Our Ref: X12292

North West Rail Link – EIS 2
SSI-5414
Submission by Mulpha FKP P/L for Norwest Business Park

Figure 6 Norwest station – heavy vehicle routes

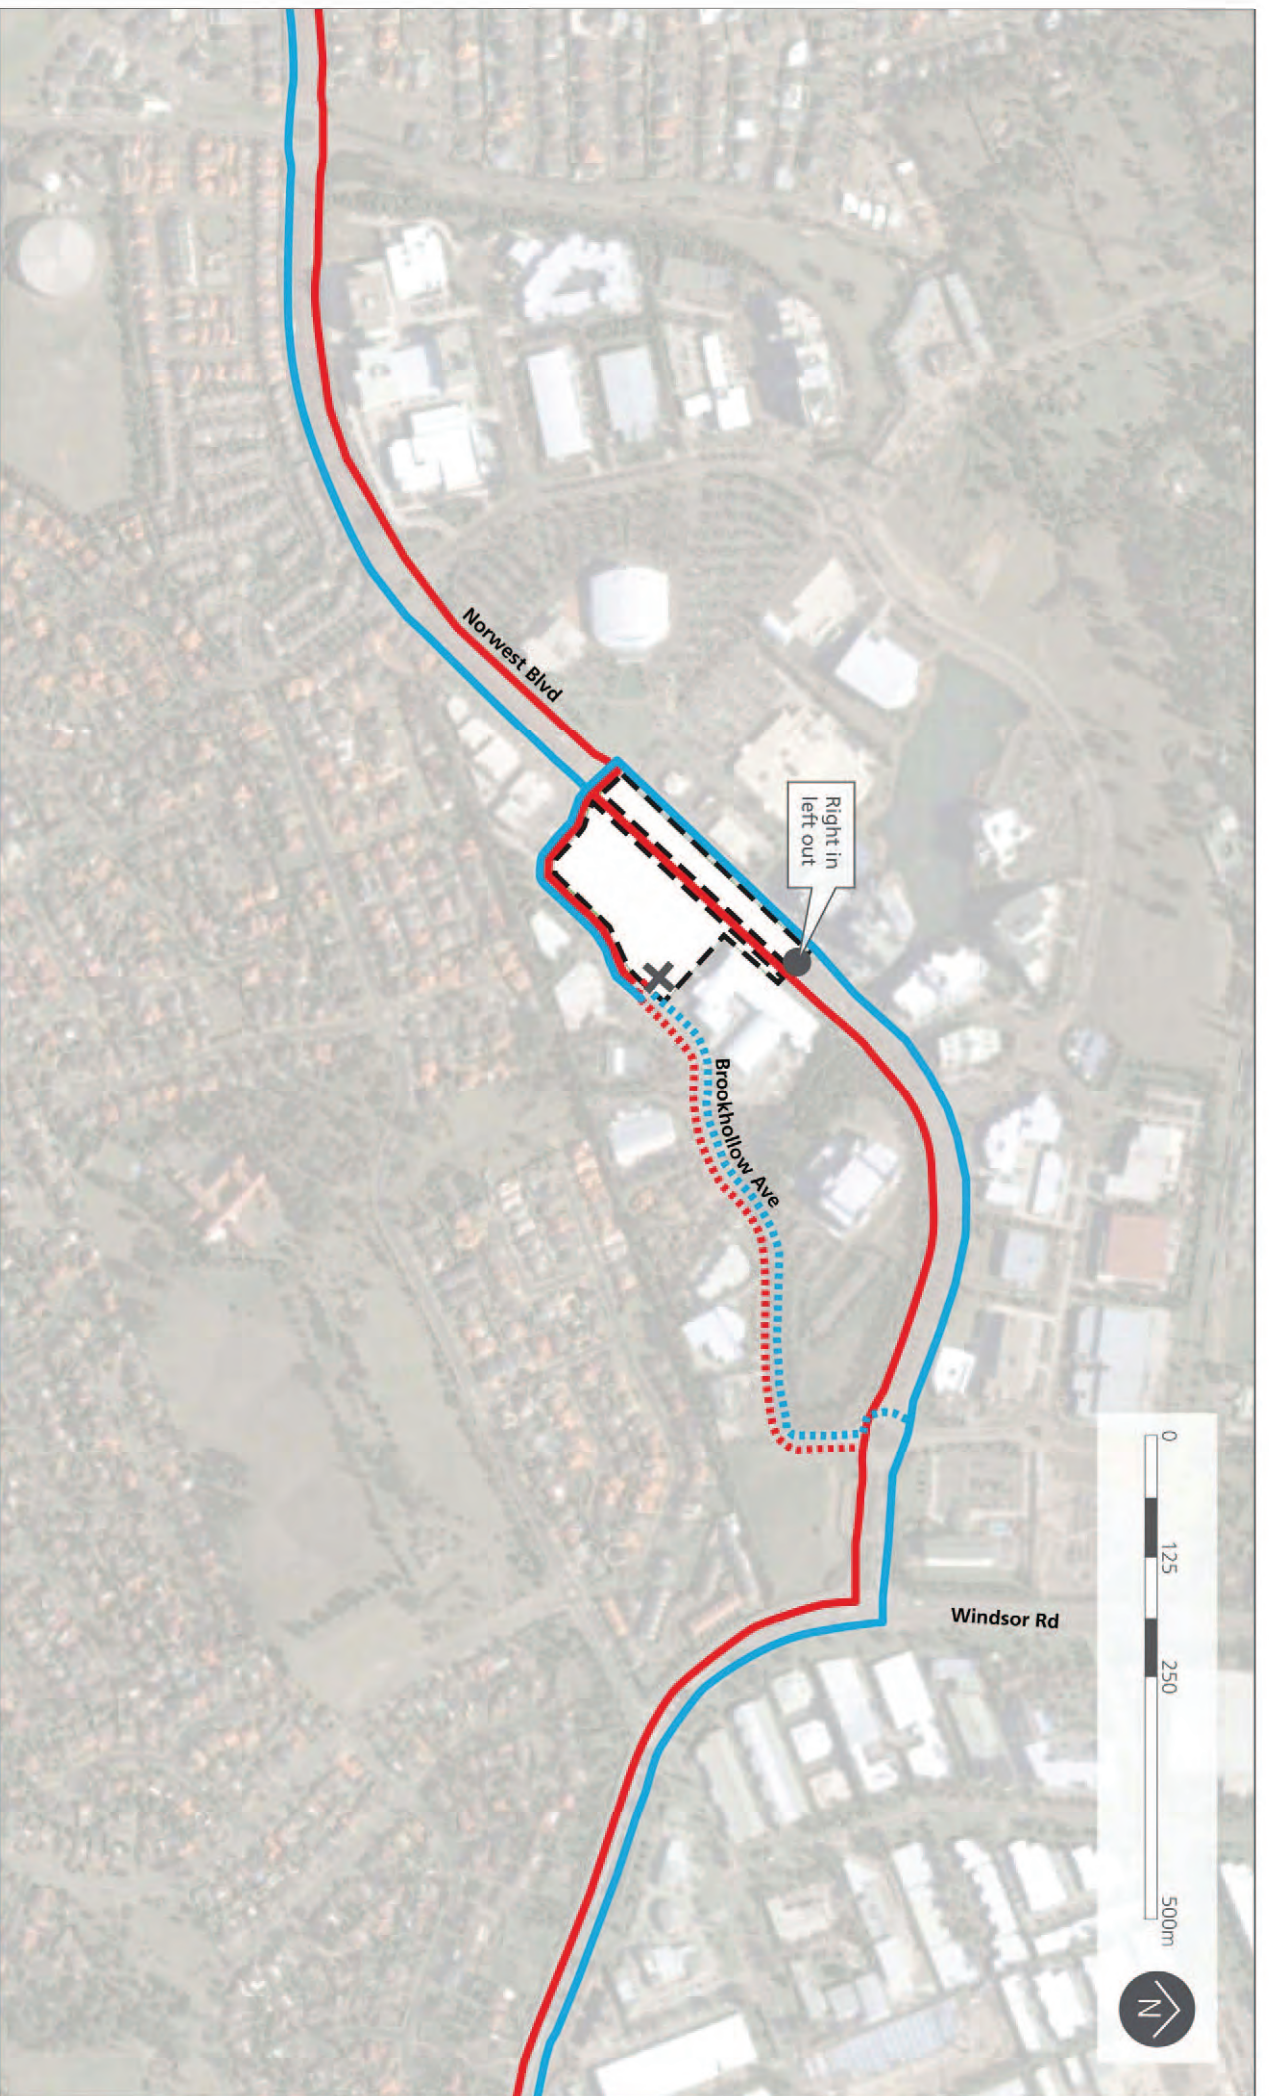
In relation to the Norwest Station the EIS 2, in the chapter on the construction methods, depicts that the intersection of Norwest Boulevard and Brookhollow Ave will be closed during the life of the construction. It is understood that the station box extends under Brookhollow Ave and necessitates the temporary closure during construction, which is identified on page 84 of the EIS 2 as being a closure for between 12 to 15 months.

The closure of Brookhollow Ave for this extended period is a significant issue and will adversely impact on the existing businesses in the area. Brookhollow Ave also provides access to Norwest Post Office and mail distribution centre which is a major public facility serving the Business Park and the surrounding area.

While the eastern end of Brookhollow Ave is accessible, this intersection is commonly congested during AM and PM peak periods and it is considered an unacceptable impact to direct all the Brookhollow traffic via the eastern end for such a long period during construction.

The EIS should consider alternate measures to reduce the closure of the western end of Brookhollow Ave such as:

- **Left in / left out arrangements at the intersection;**
- **Alternate temporary arrangements to provide access to Brookhollow Ave; and**
- **The southern end of the station box being constructed first with road access reinstated as early as possible to provide full access to Brookhollow Ave.**

Figure 6.23 Northwest Station - Indicative layout

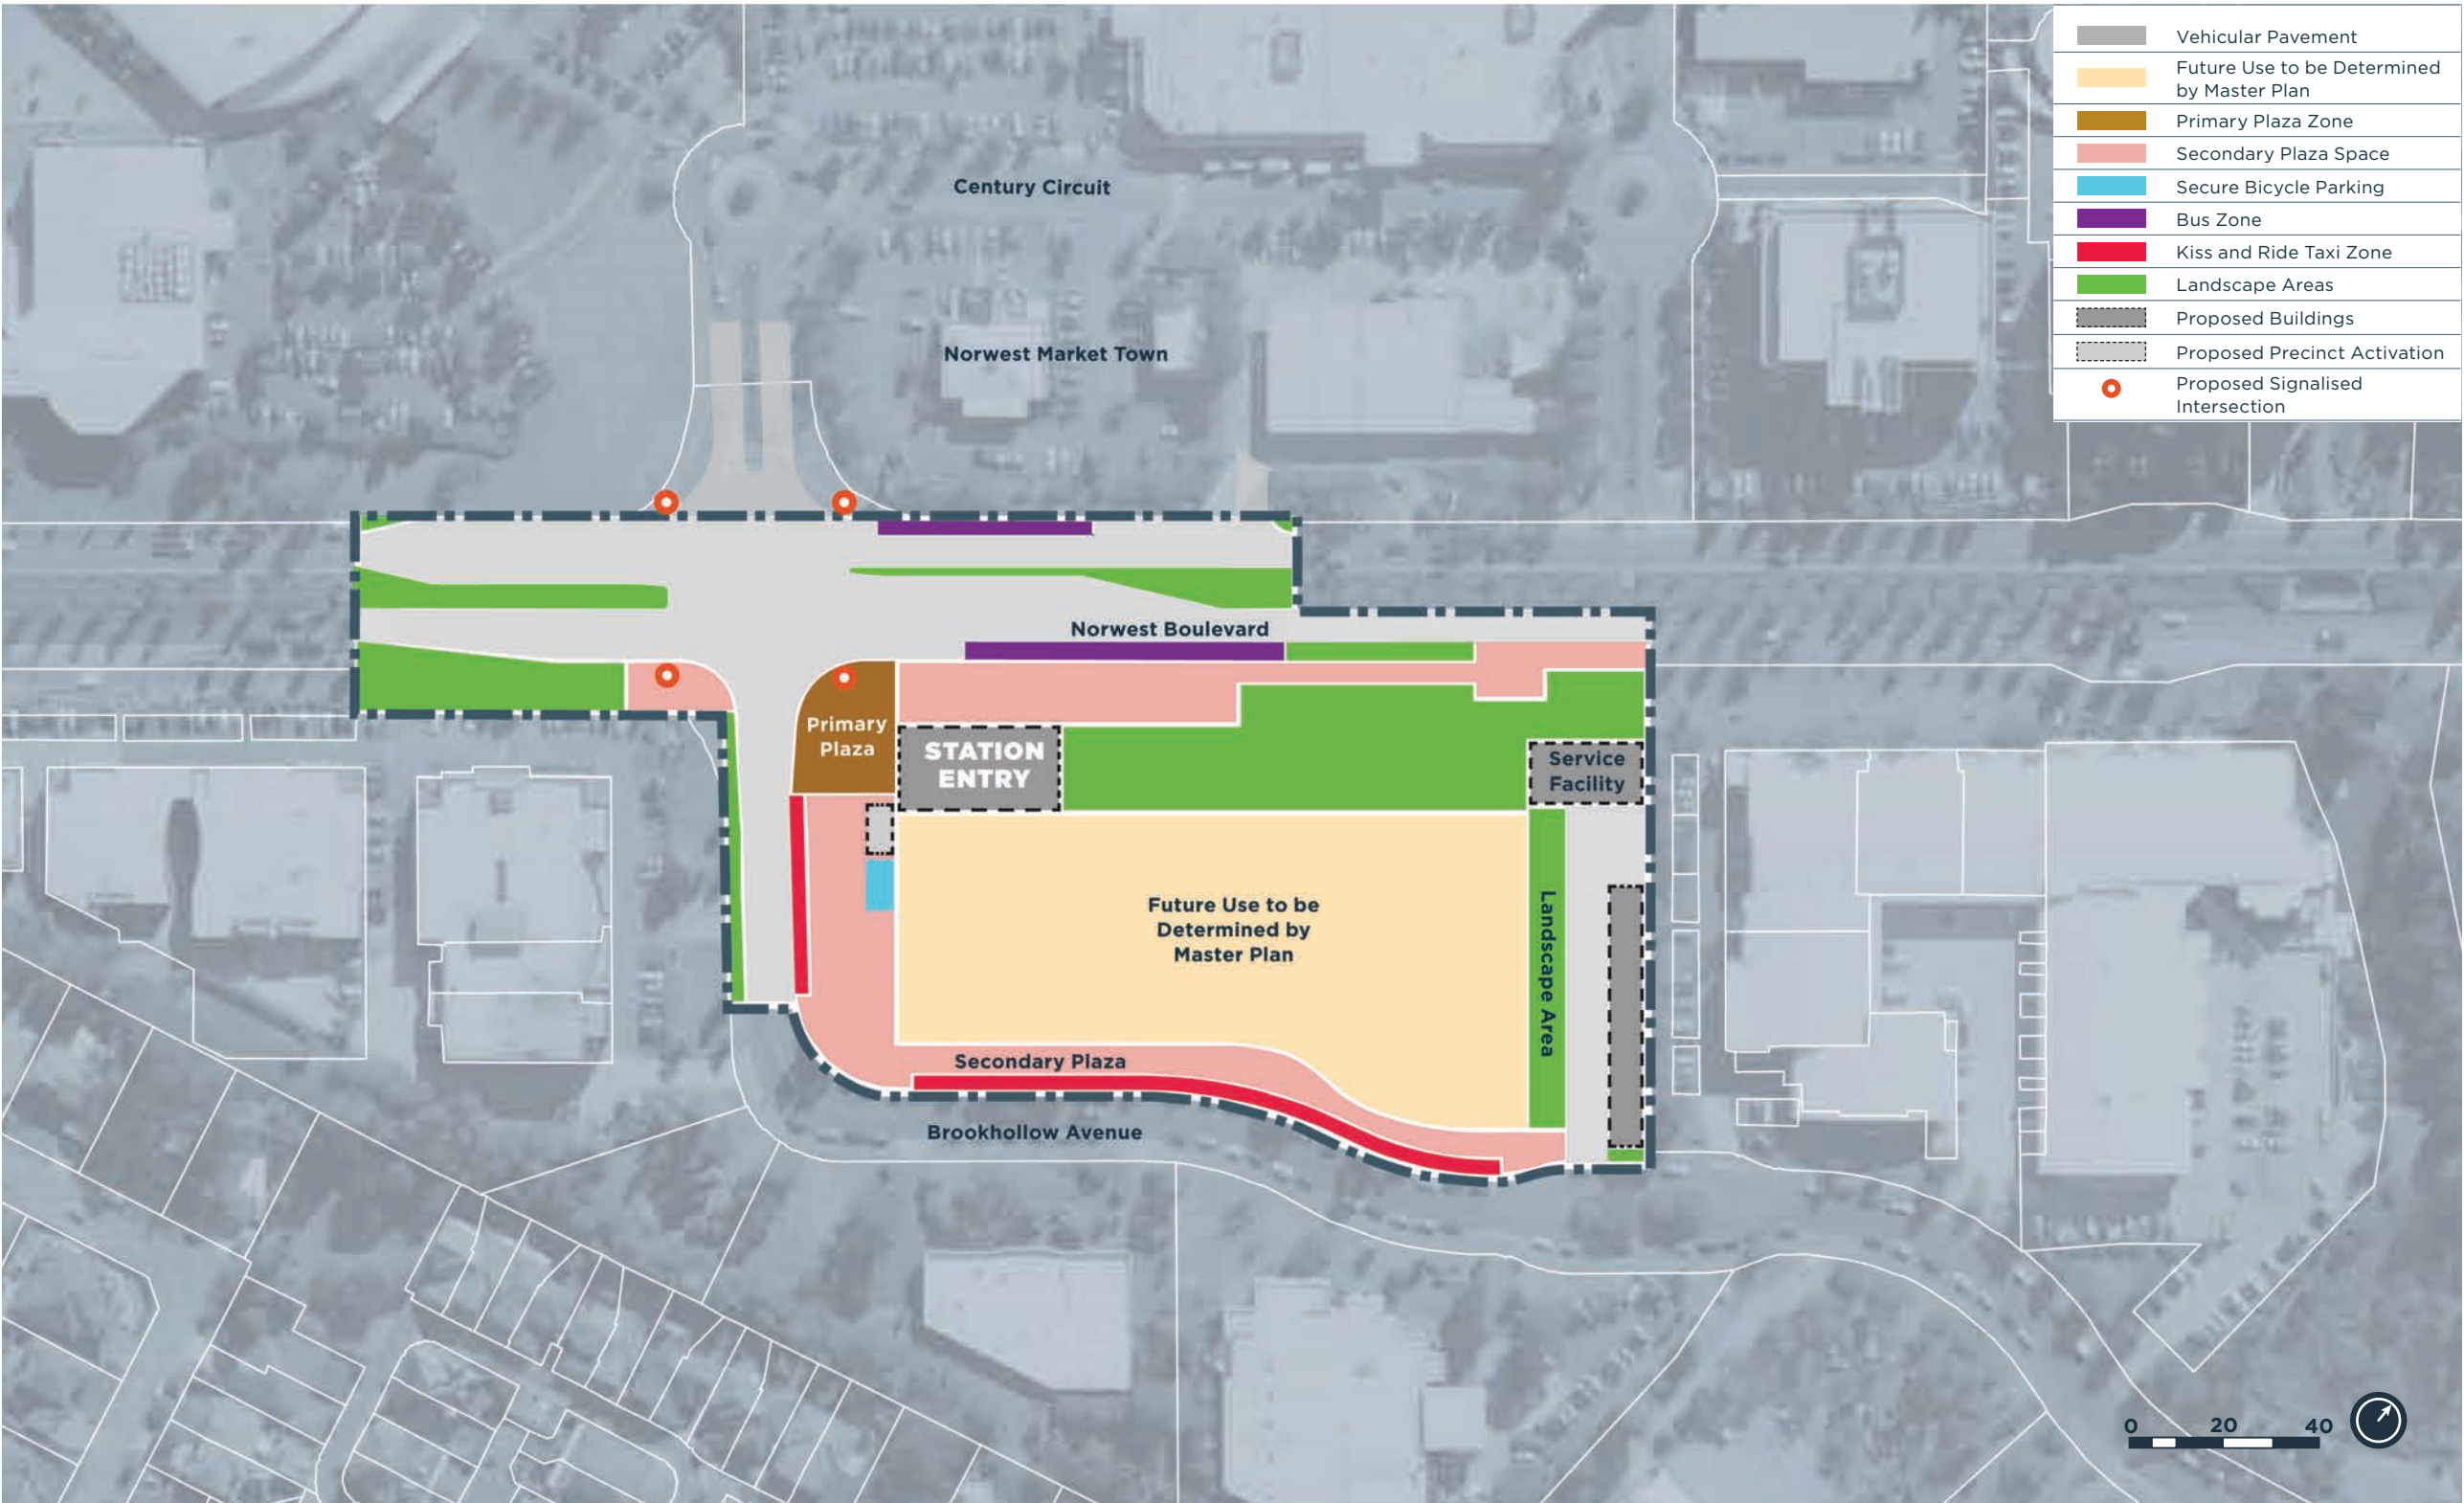
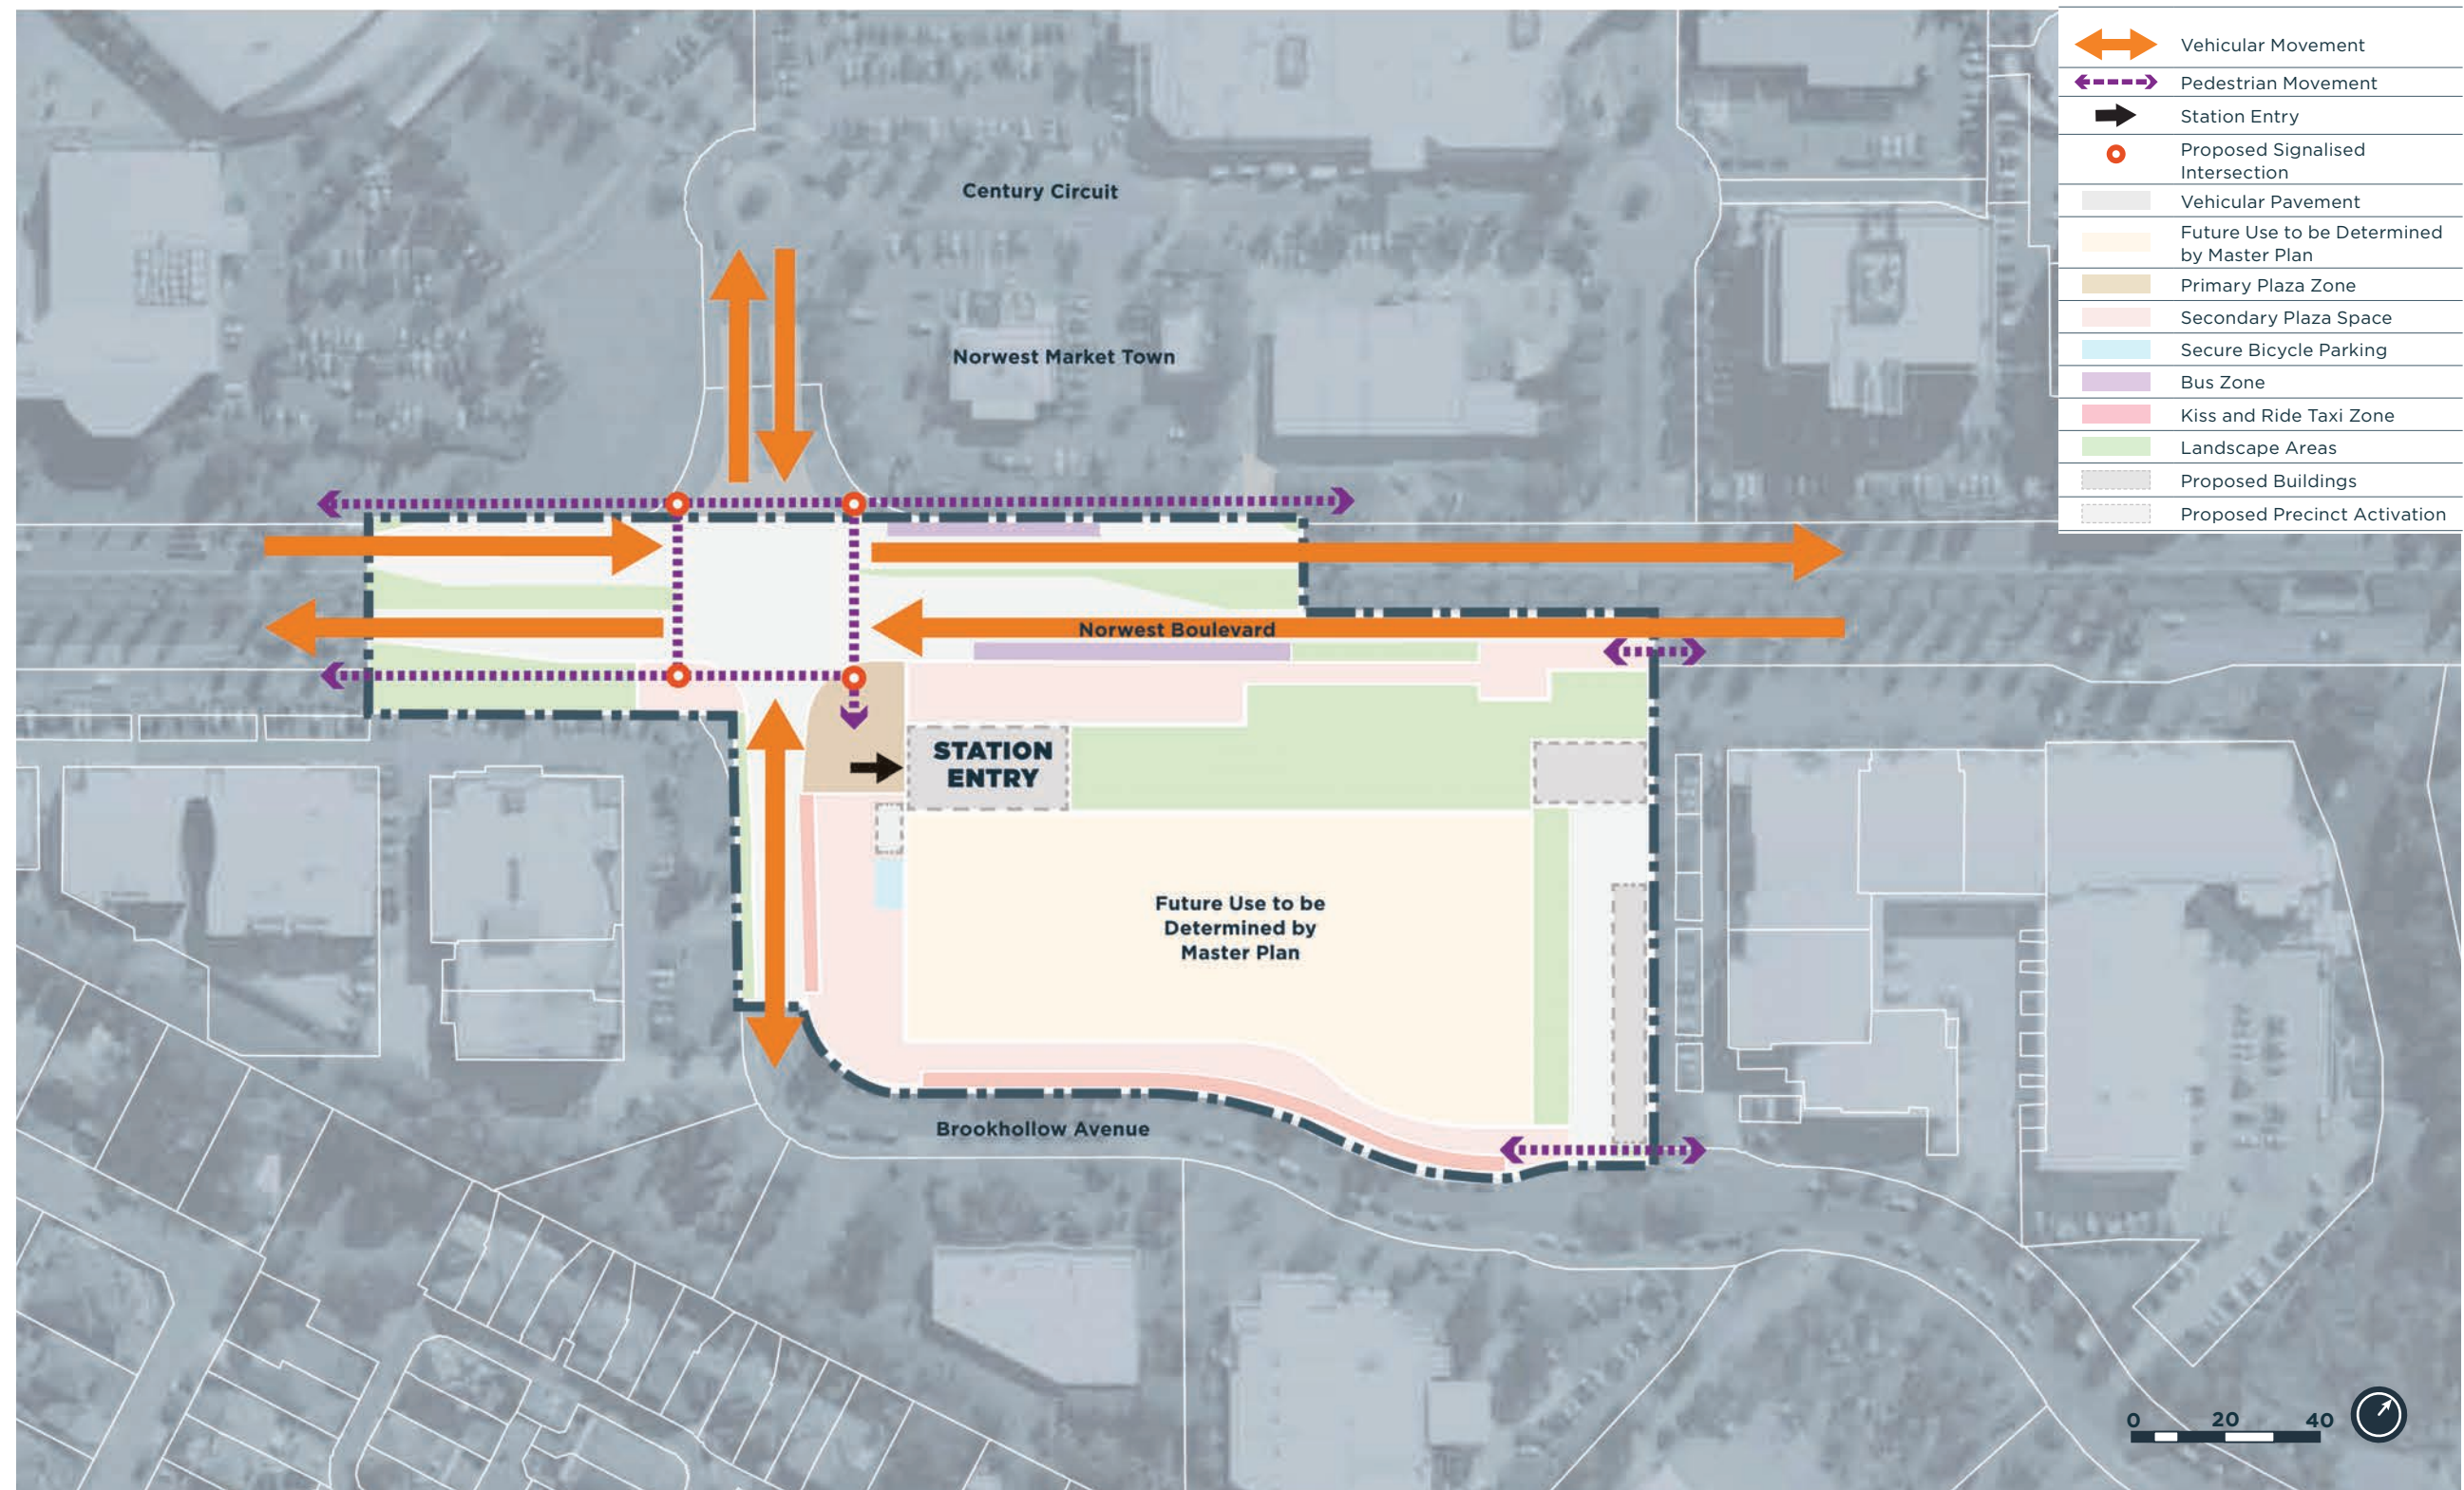
This station is located in proximity to the local retail centre being the Norwest Shopping Centre and is ideally placed to serve the surrounding commercial area. The main area of concern is the provision of pedestrian access to the station entry.

The EIS 2 refers to the replacement of the Norwest Boulevard and Brookhollow Ave roundabout with a traffic signalised intersection to improve pedestrian safety. This is recognised as an improvement for pedestrian access together with the bus zones that need to be provided on each side of Norwest Boulevard. **The provision for an underground connection to the station should be allowed in any redevelopment plans on either side of Norwest Boulevard.**
